RE: **HOLIDAY BREEZE SUBDIVISION (F-22/D36)**
Engineers Certification- (additional detail sheets submitted)
Engineers Stamp dated 10/29/1998, Rev. 1/25/1999, 4/21/1999, 6/26/2002
Engineers Certification dated 3/21/2002

Based upon the information provided in your Engineers Certification dated 3/21/2002, and the subsequent sheets submitted 6/26/2002 providing details of the drainage structure at the end of the new cul-de-sac, and the removal of the proposed bollards and insertion of the new retaining wall, the above referenced plan is adequate to satisfy the Grading and Drainage Certification for the above referenced project.

RE: **HOLIDAY BREEZE SUBDIVISION (F-22/D36)**
Engineers Certification For Release of Financial Guaranty
Engineers Stamp dated 10/29/1998, Rev. 1/25/1999, Rev. 4/21/1999
Engineers Certification dated 3/21/2002

**Re: Holiday Breeze Subdivision Amended Grading Plan
Engineer's Stamp dated 4-20-01 (F22/D36)**

CITY OF ALBUQUERQUE PUBLIC WORKS DEPARTMENT ENGINEERING DEVELOPMENT GROUP	
TITLE: HOLIDAY BREEZE SUBDIVISION GRADING PLAN	
Design Review Committee	City Engineer Approval
City Project No. XXXXXX	Zone Map No. F-22
Sheet 1	Of 1

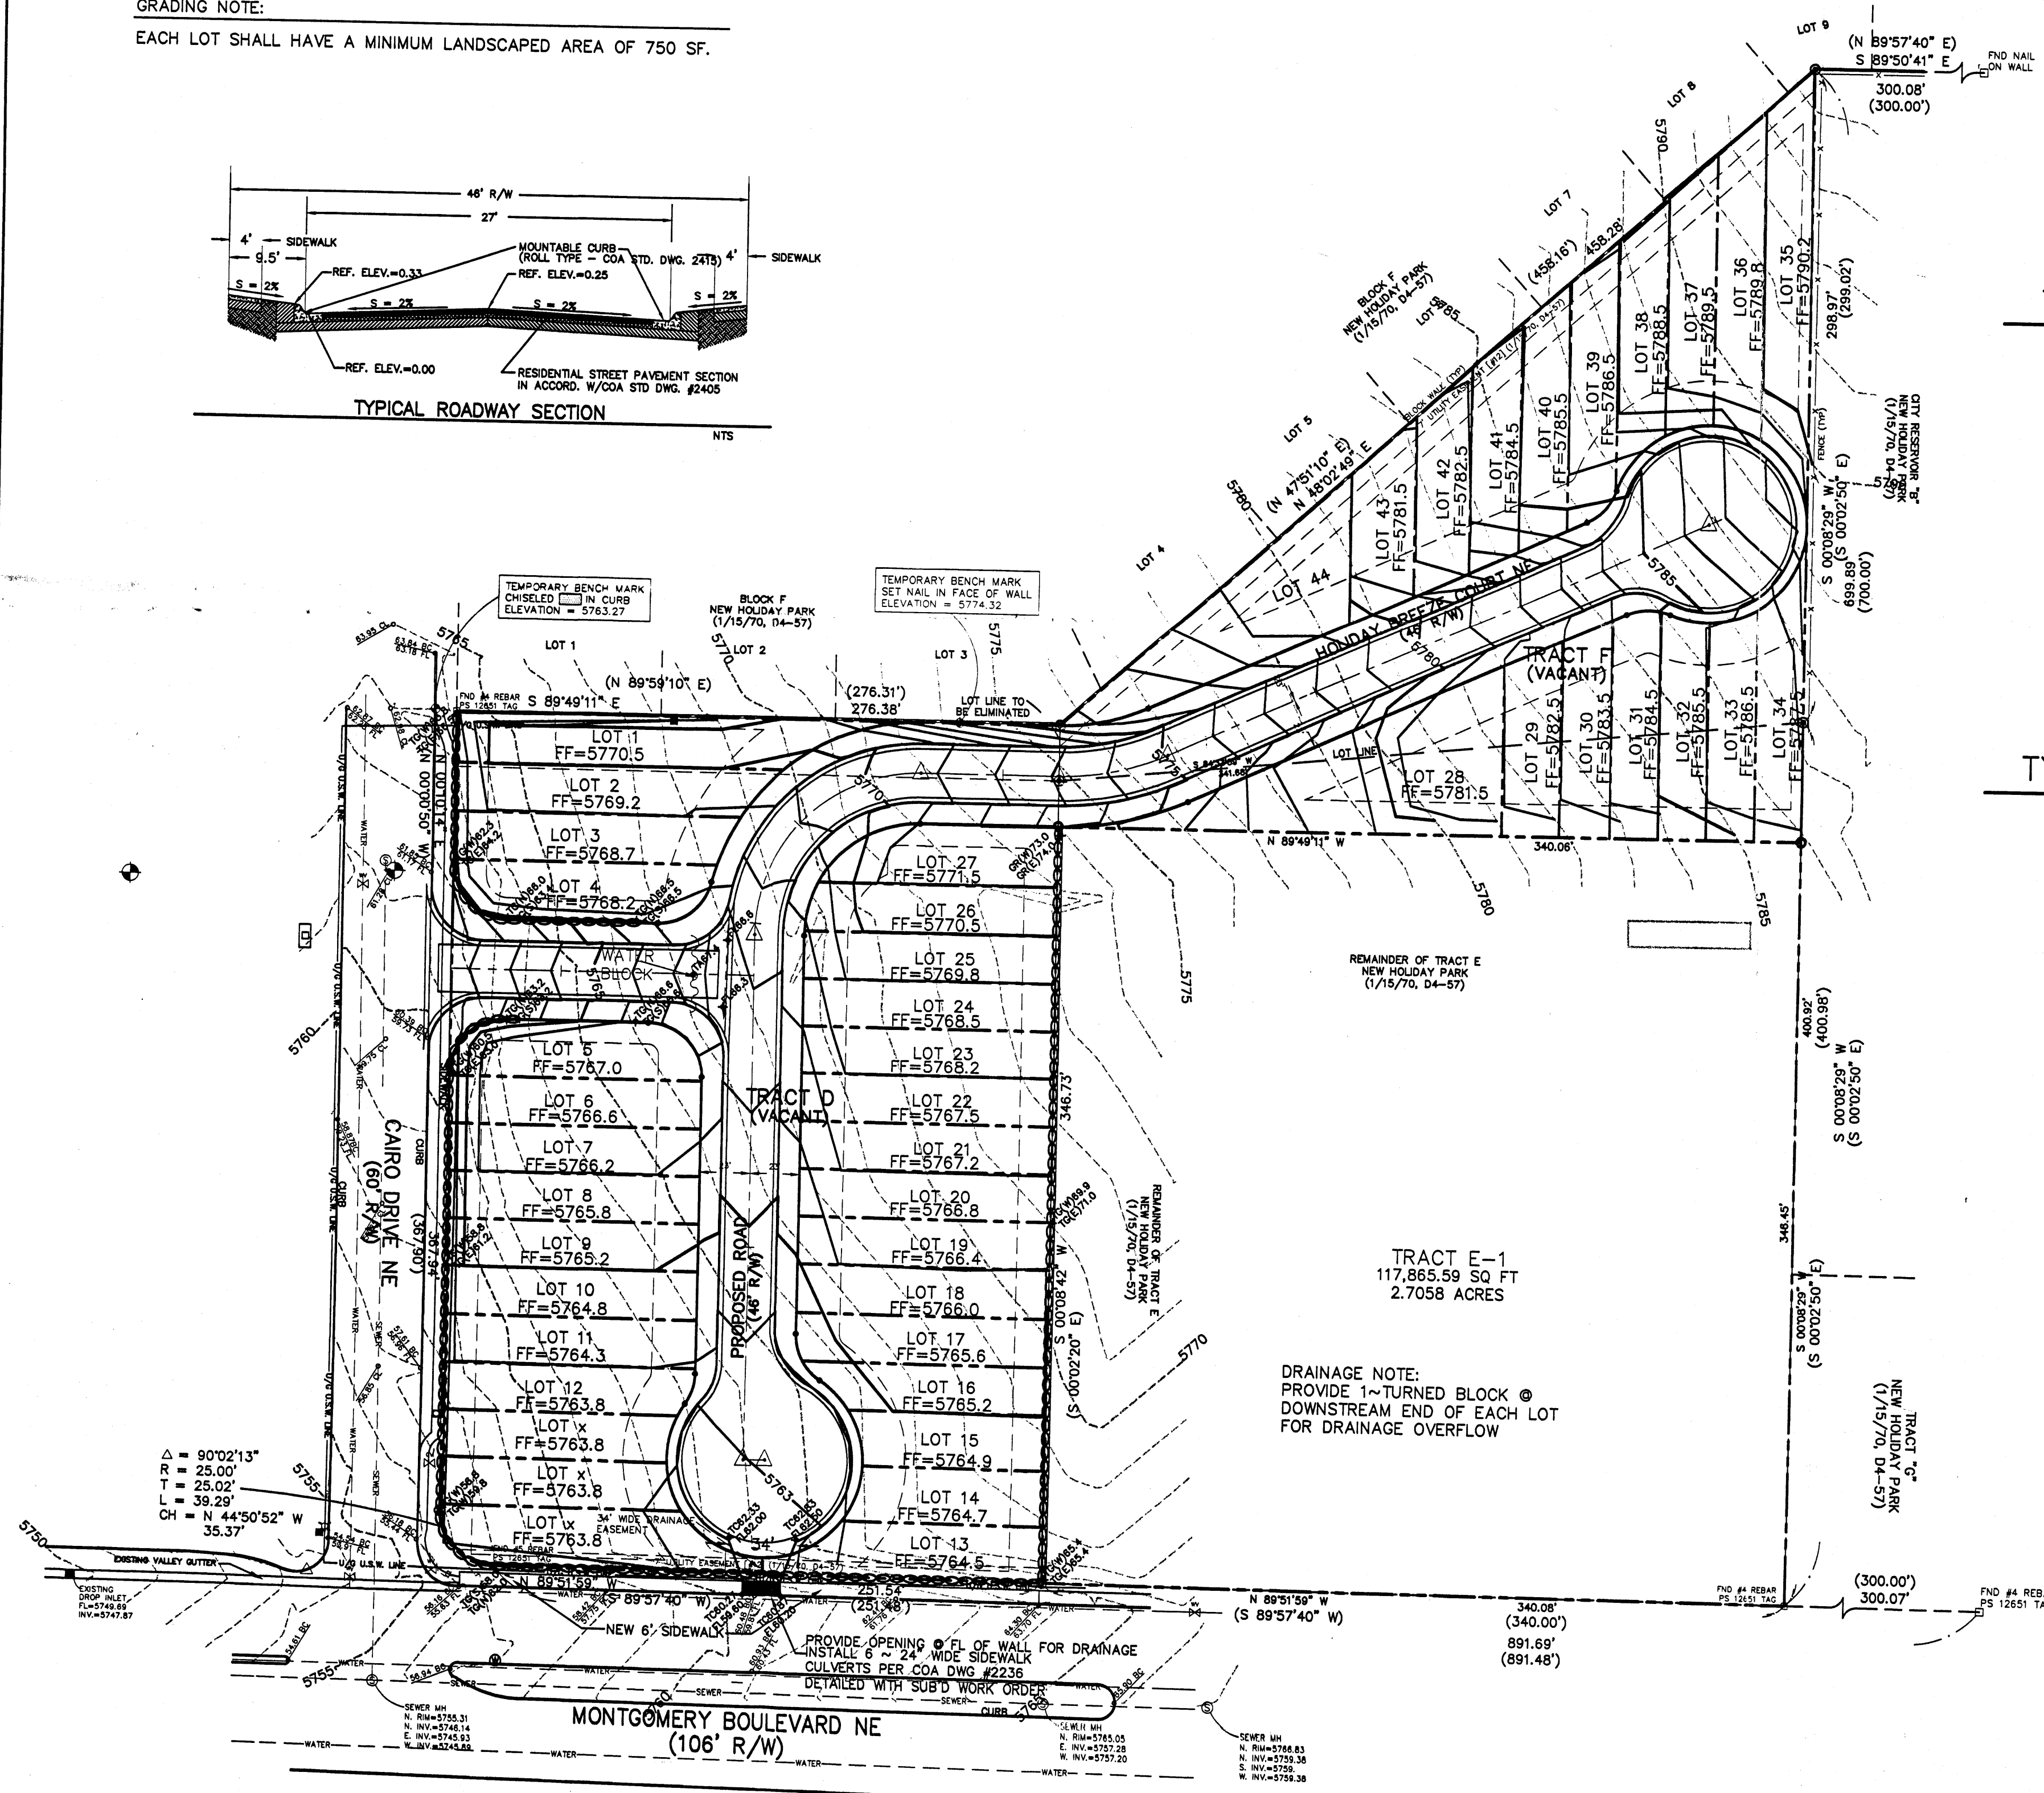
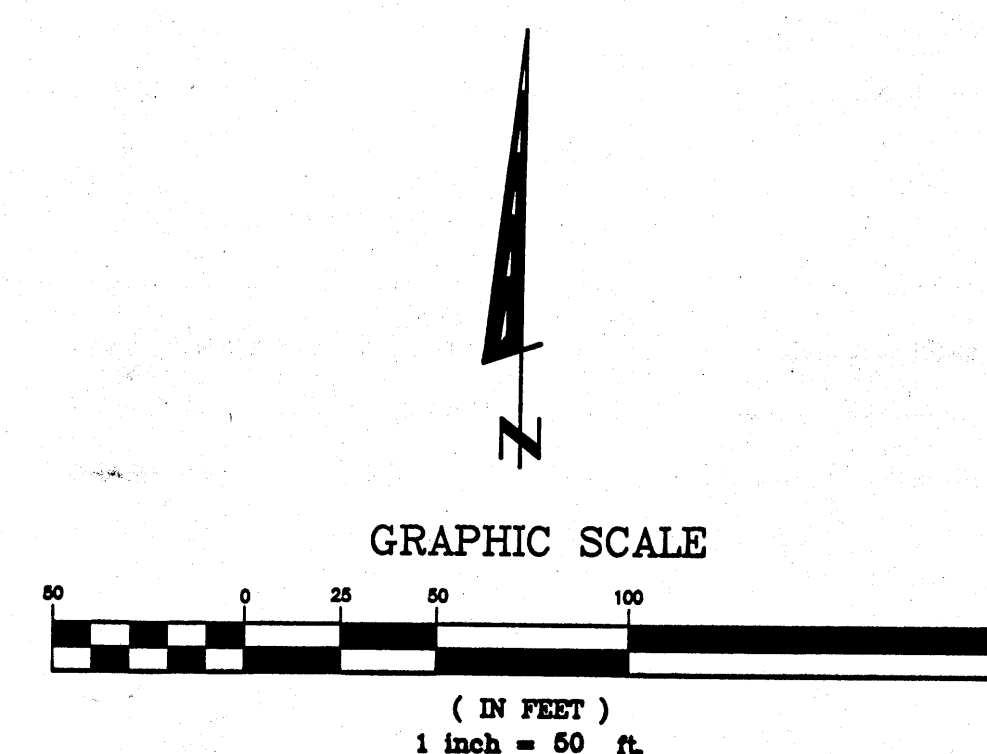
2. Your developed drainage plan calls for the offsite valley gutter to run along lots 34 & 35, yet the plan does not call for this. Also, to convey these offsite flows to Montgomery, it would appear that this same valley gutter will have to run adjacent to the entire east side of the site.

3. How will the offsite flows within the valley gutter enter the Montgomery right-of-way? Are not sidewalk culverts needed at this location as well?
4. With the relatively steep onsite road grade, I am concerned that storm waters may not be retained within the road in the area of the curve to the south. Are you comfortable that a hydraulic jump will not occur in this location?

5. Your plan calls for back yard retention ponds. Why then does the plan also call for wall openings to allow for cross-lot drainage?
6. The lot sections, as shown, are not acceptable. I believe you may want to change the

both of these to more accurately reflect your plan. Ponding against a retaining wall is not recommended, and it appears that the wall footing on the upstream lot section will be undermined, thus jeopardizing the structural integrity of the retaining wall.

1. The drainage plan has been revised and is at a larger scale and more legible.
2. No hydraulic jumps occur within the proposed subdivision. We have analyzed the worst case scenario and the 100 year maximum flow will remain in a supercritical state. See the attached calculations.
3. We have added a retaining wall along the north side of Lot #1.
4. The note has been removed. All roof drainage and driveway drainage is directed at the street. The only runoff to the back yards is what falls on it.
